BUILDING INSPECTION PERMIT

Permit Number: 050970

This is to certify that Swan David C/Owner
 has permission to change roof line of commercial storage additional storage space
 AT 364 Cumberland Ave 037 D003001

Proposed Project Description:
change roof line of commercial storage shed to add additional storage space

**A1**

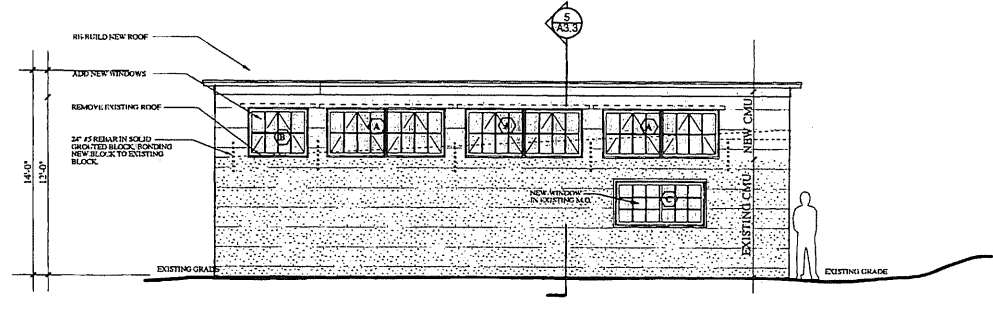
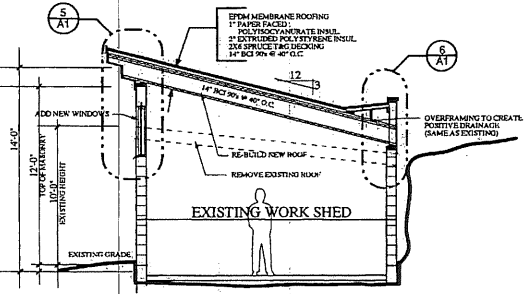
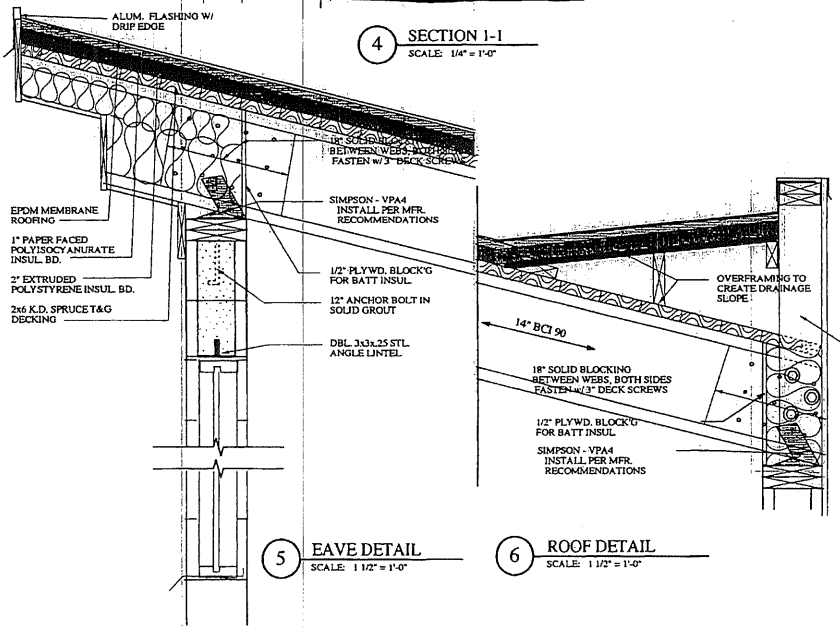
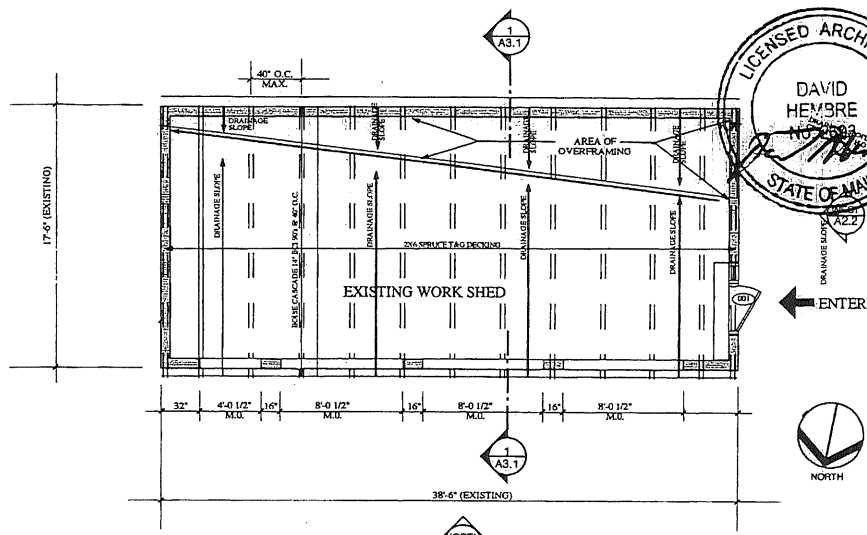
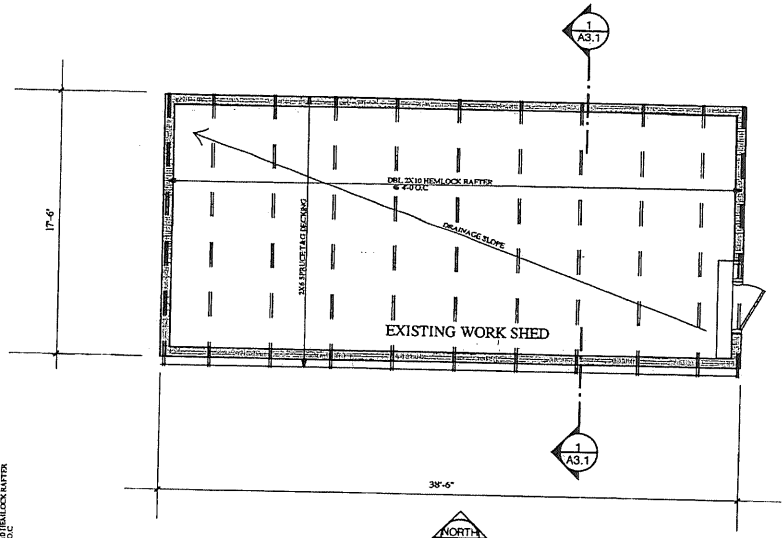
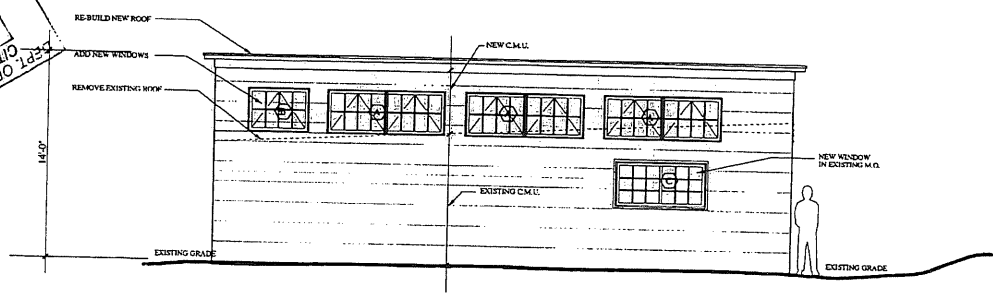
Comments:
7/26/2005-mjn: Need structurals for wall extensions, rafter ties and lintels, spoke with owner and Architect.
10/3/2005-ldobson: Dropped additional info by took off hold put in MJN basket LJD
